PLANNING AMENDMENT

Application No. H06/0384/01
Date Registered 08 MAY 2008
Case Officer LS

3 bed house +
Garage

3 BEDROOM HOUSE & GARAGE, MAIN ROAD, GEDNEY DROVE END.

SITE PLAN

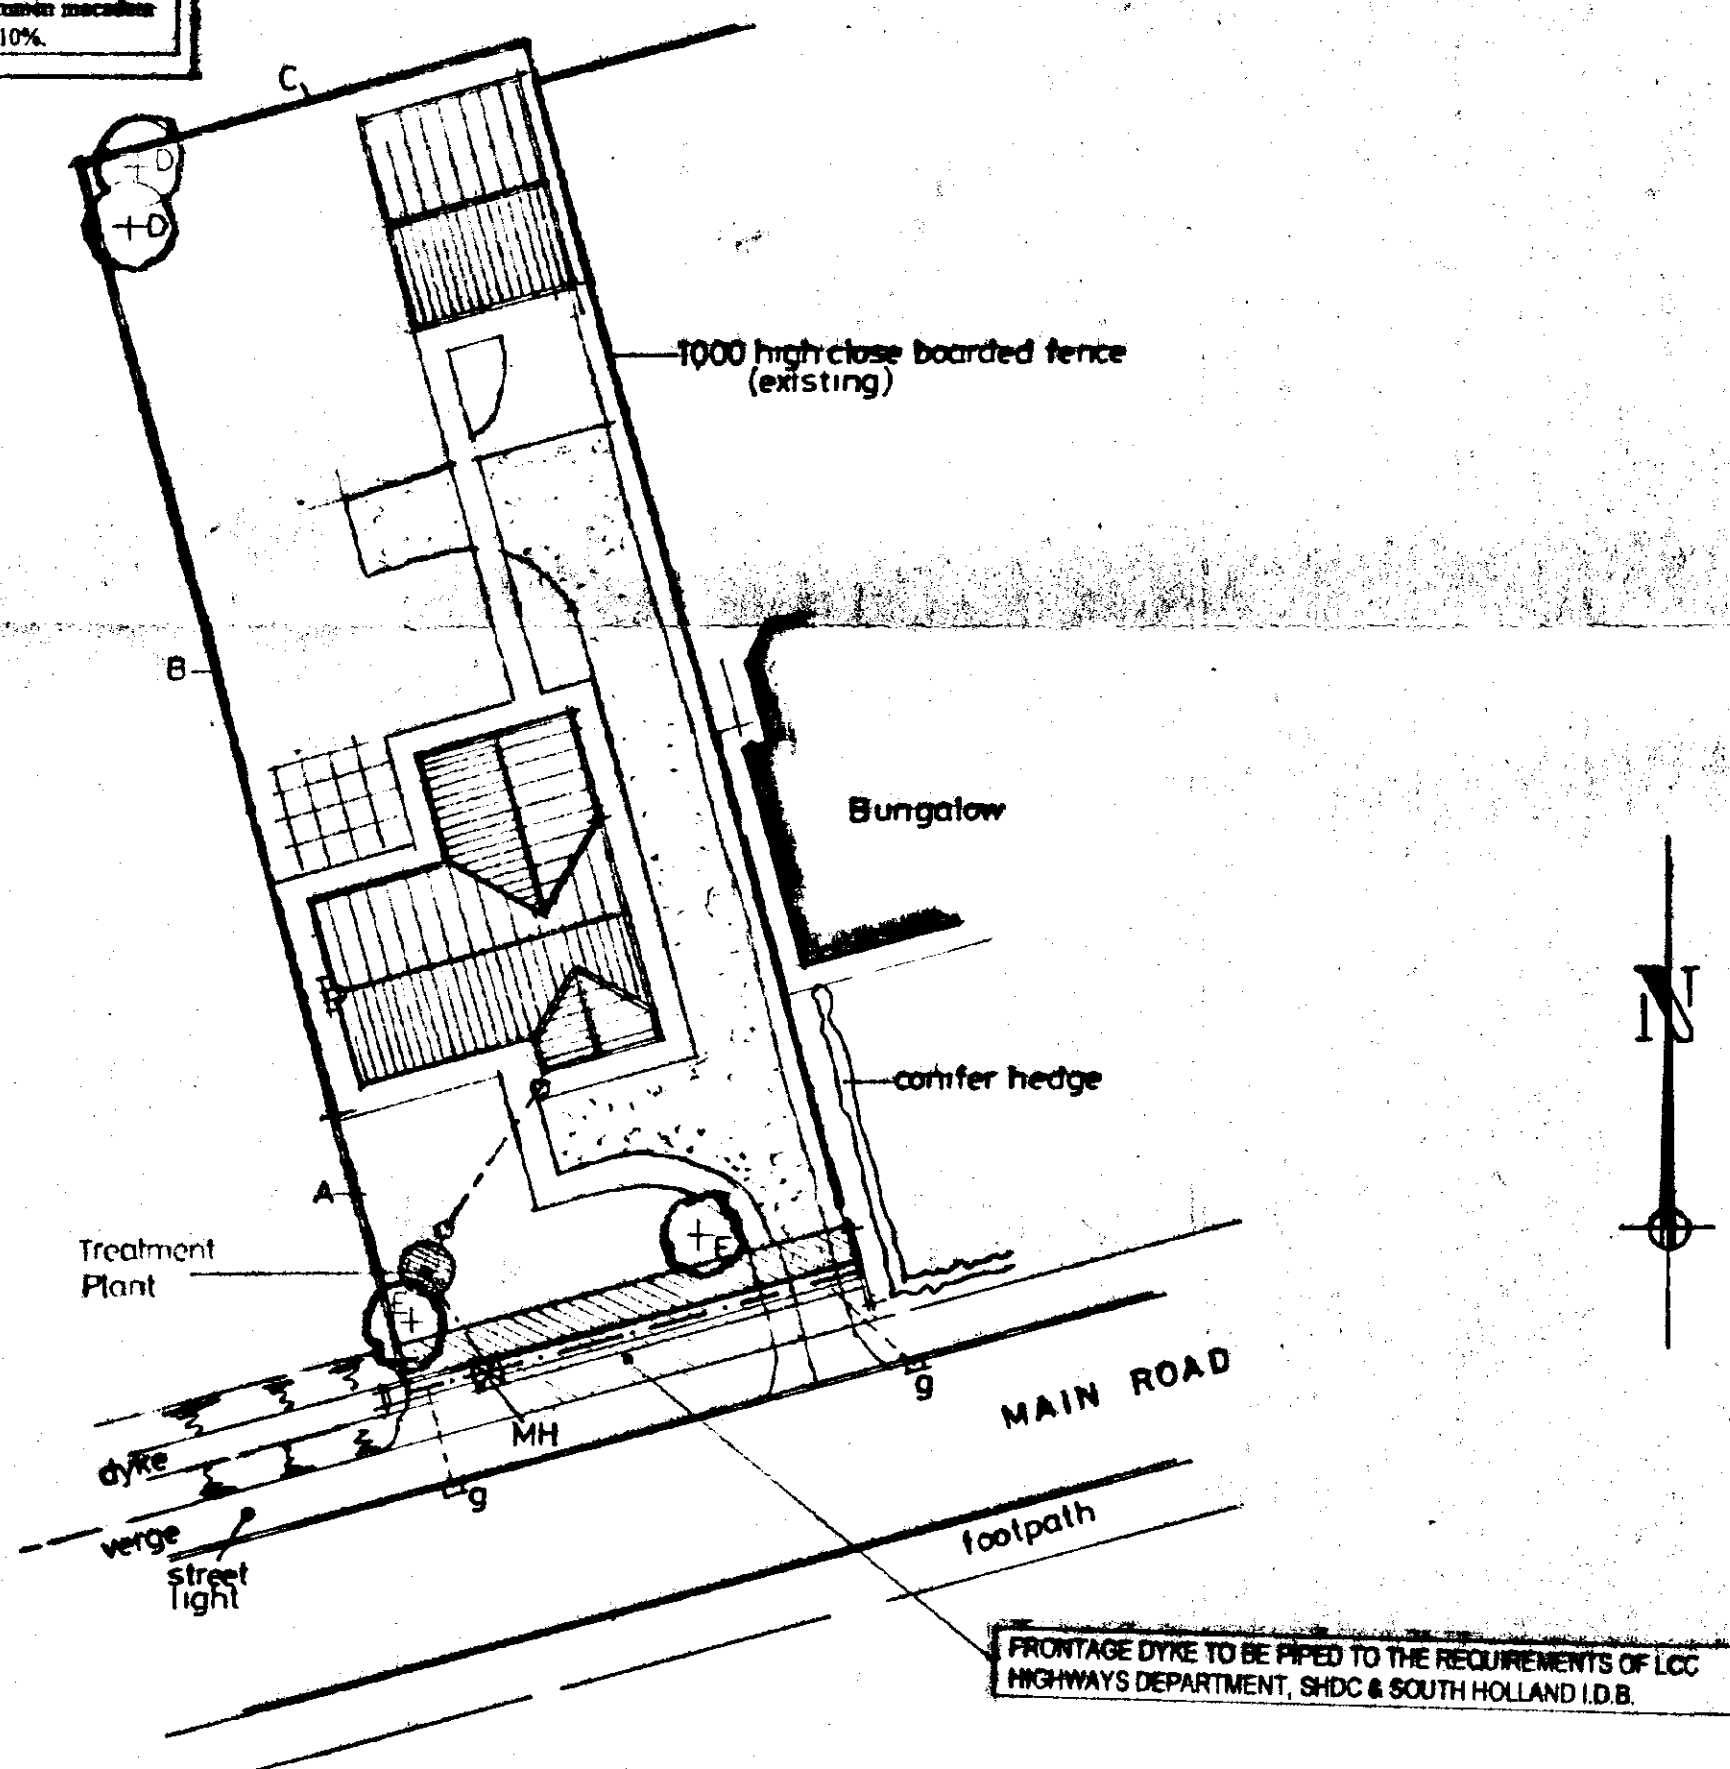
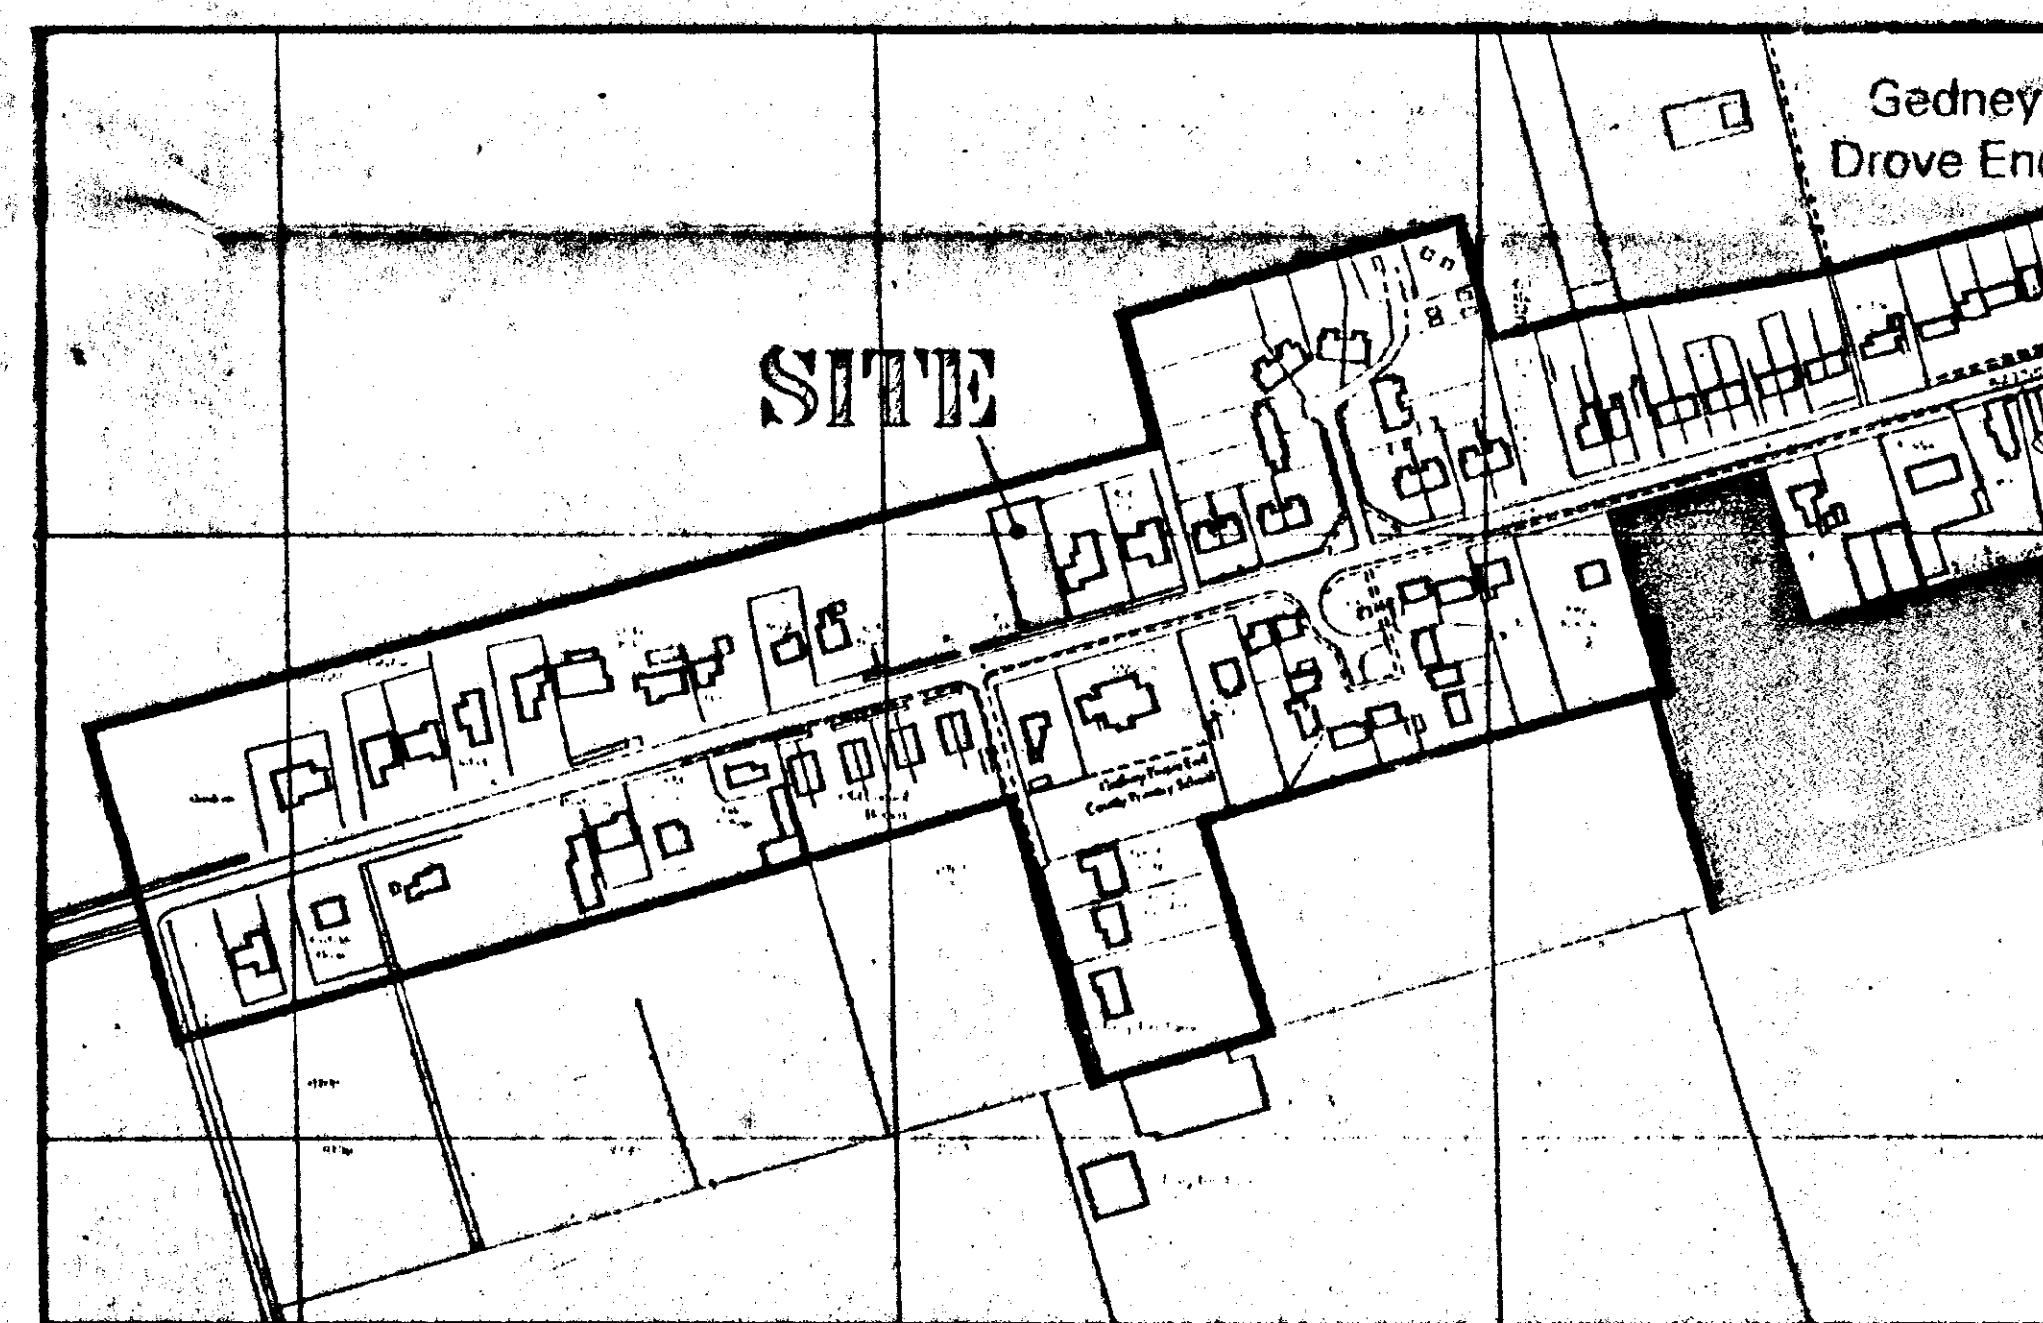
move Position
of House forward
by 2.5mts

With reference to the above application and our recent discussions regarding your concerns over the position of the house in relationship to the adjacent bungalow to the East.

I have discussed all the matters we discussed with my clients and they propose to move the house forward by 2.5 metres, therefore please find enclosed amended plans as requested.
